09/10/2019

**Prince of Wales Hospital - Addition to approved Acute Services Building (SSD-10339)
Response to Submissions**

Figure 23: Anticipated daily profile of traffic on Magill Street

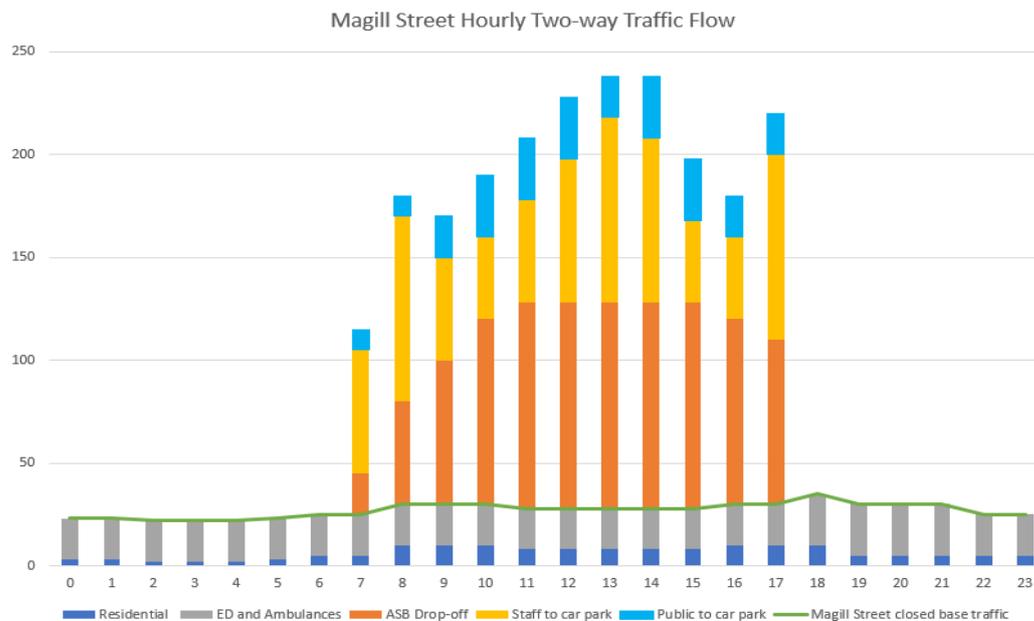
- identify and provide appropriate mitigation to address the additional amenity impacts on properties affected (adjoining Magill Street and Hospital Road) by the opening of Magill Street and the additional through traffic along Magill Street.

SITE PLAN SHOWING CLINICAL & PEDESTRIAN CONNECTIONS AT LEVEL 00

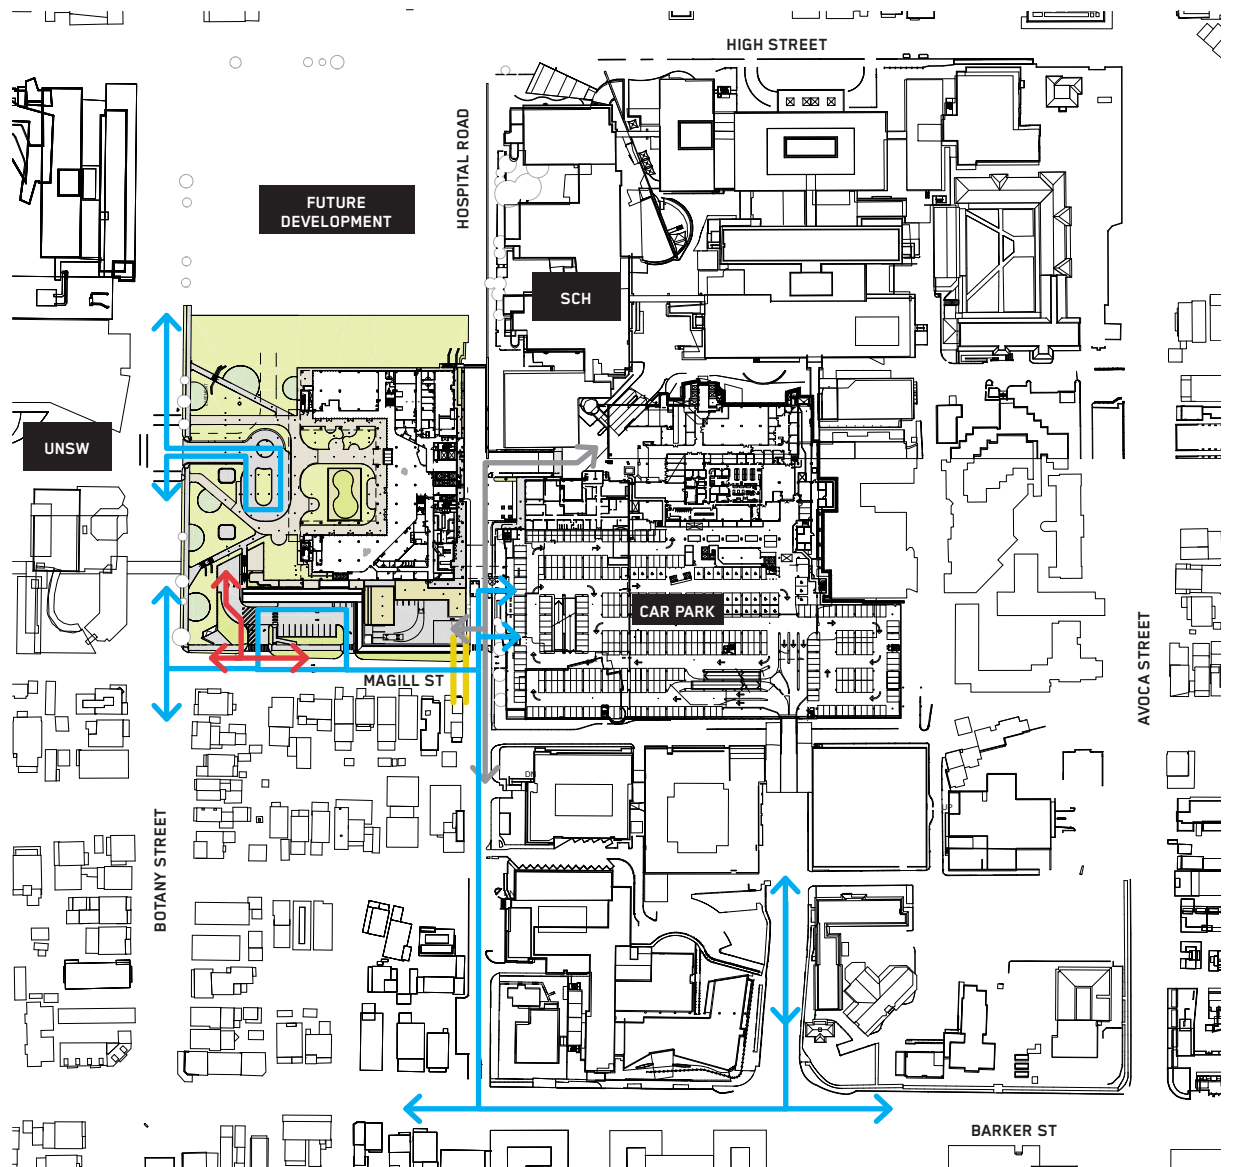
- organise the internal spaces on Level 0 adjacent to the public plaza to activate the public space and provide views into the operations of the building.

FACADE SECTIONS

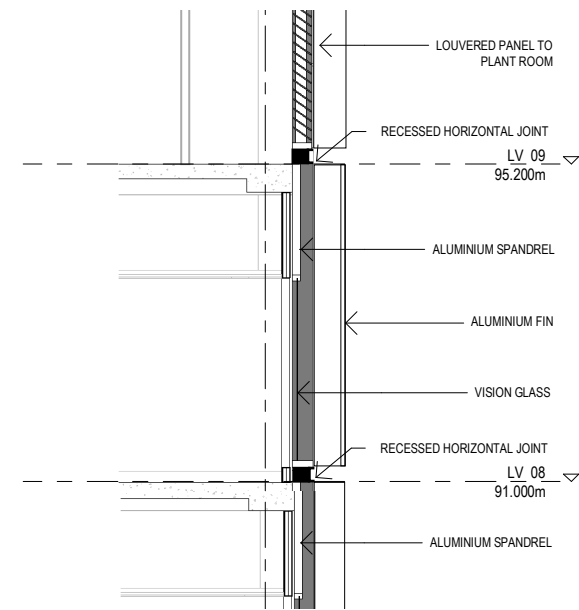
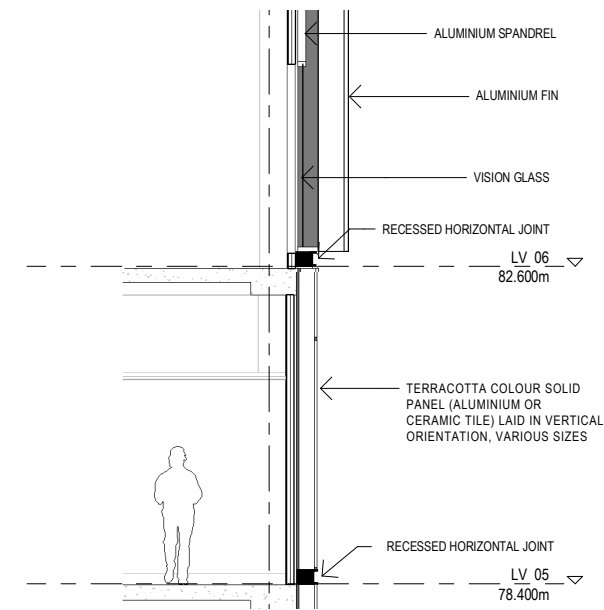
- provide further articulation of the façade to develop the desired outcomes of colour, texture, playfulness, framing of views and the relationship to the Ainsworth Building.

BRIDGE FACADE

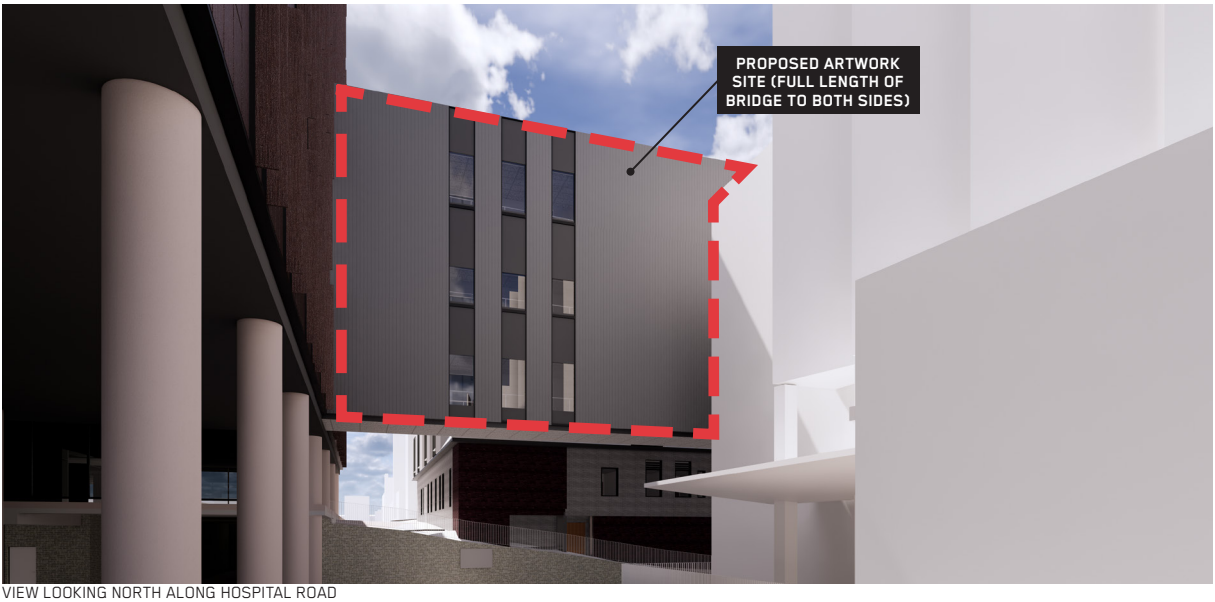
- reconsider the use of obscuring film to minimise privacy impacts on Ainsworth House.
- consider integrating public art on the façade of the link bridge, including interpretative elements which recognise the significance of indigenous culture and heritage on the site.
